Planning Inspectorate Reference: EN010098
MMO Reference: DCO/2018/00014
Identification Number: 20029896

Planning Act 2008 - Application by Ørsted Hornsea Project Four (UK) Limited (“Ltd”) for an Order Granting Development Consent for Hornsea Project Four Offshore Wind Farm

Deadline 8 Submission

Figure 1: Southern North Sea SAC in Relation to the Hornsea Four Order Limits.

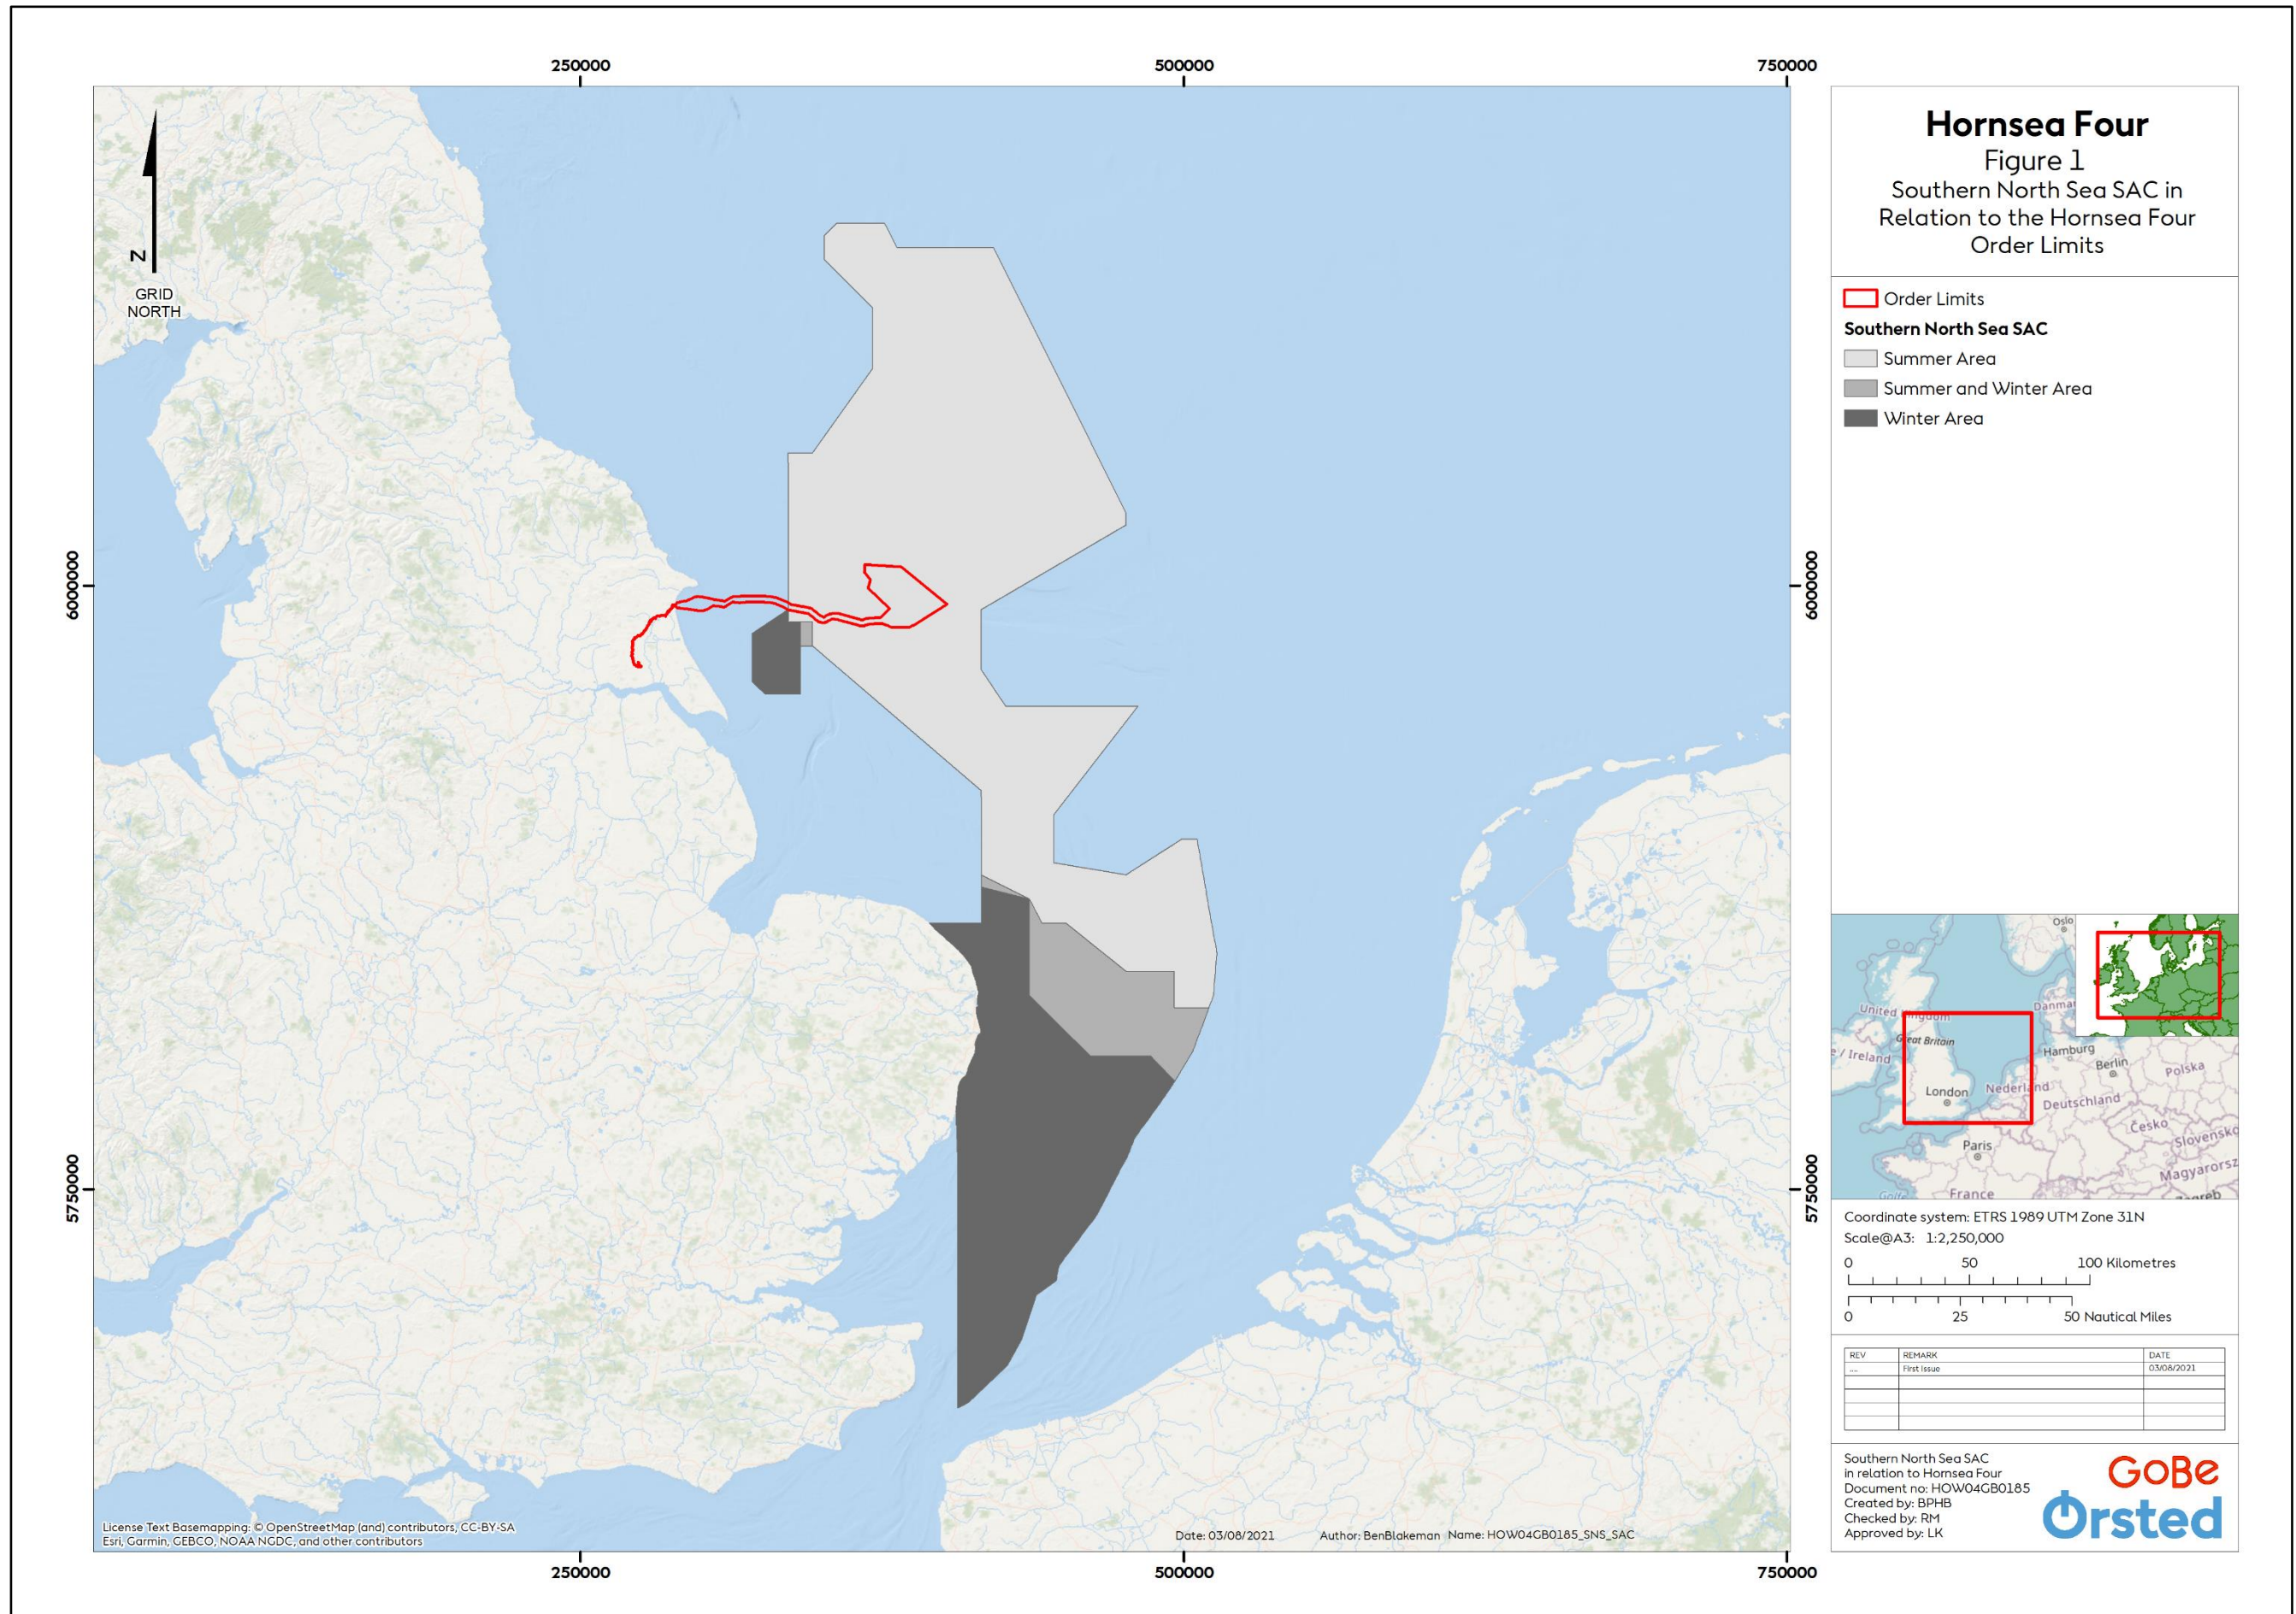
1.2.2. The MMO believes the outline SNS SAC SIP is robust and contains the necessary information required at this stage. We note that this Outline SNS SAC SIP is intended to identify the available mitigation and management measures that could be brought forward during the development of the final SNS SAC SIP prior to the construction of Hornsea Four, that ensures that a conclusion of no Adverse Effect on Integrity (AEol) can be maintained under all scenarios.

1.2.3. We also note that any requirement for noise mitigation shall be determined following confirmation of final hammer energies and foundation types, collection of additional survey data (noise or geophysical data), and/or acquisition of noise monitoring data, the update of the project and location specific noise model(s) including information on maturation of emerging technologies. The mitigation measure (or suite of measures) that may be implemented during the construction of Hornsea Four will be determined in consultation with the regulator and relevant statutory nature conservation body.

1.2.4. With regard to the project in-combination assessment, the final SNS SAC SIP will confirm which plans and projects fall within the construction timeframe for Hornsea Four and therefore which plans and projects require further consideration in-combination with Hornsea Four. The purpose of the process being to confirm whether the conclusion of no AEol in-combination is valid in the absence of additional mitigation, and if not, which measure(s) is required to provide that certainty.

1.2.5. However, the MMO reiterates the request made at Deadline 7 [REP7-111] that the following is clarified.

1.2.6. Page 16 of the document sets out the following Commitment: “Co85 – There will only be a maximum installation of 2 piled foundations within a 24 hour period. It is possible for installation of the two piled foundations to occur concurrently i.e., within a 24 hour period at up to two locations within the HVAC search area or up to two locations within the array. The two piled foundation locations may also be piled simultaneously”. This statement is confusing as ‘concurrently’ and ‘simultaneously’ have the same meaning. Presumably, the Applicant means that consecutive piling is likely (i.e., up to two piles installed in a 24-hour period, one after the other) but simultaneous piling may also occur (two piles installed in different locations at the same time within either the HVAC area or within the array). We request that the Applicant clarifies this.
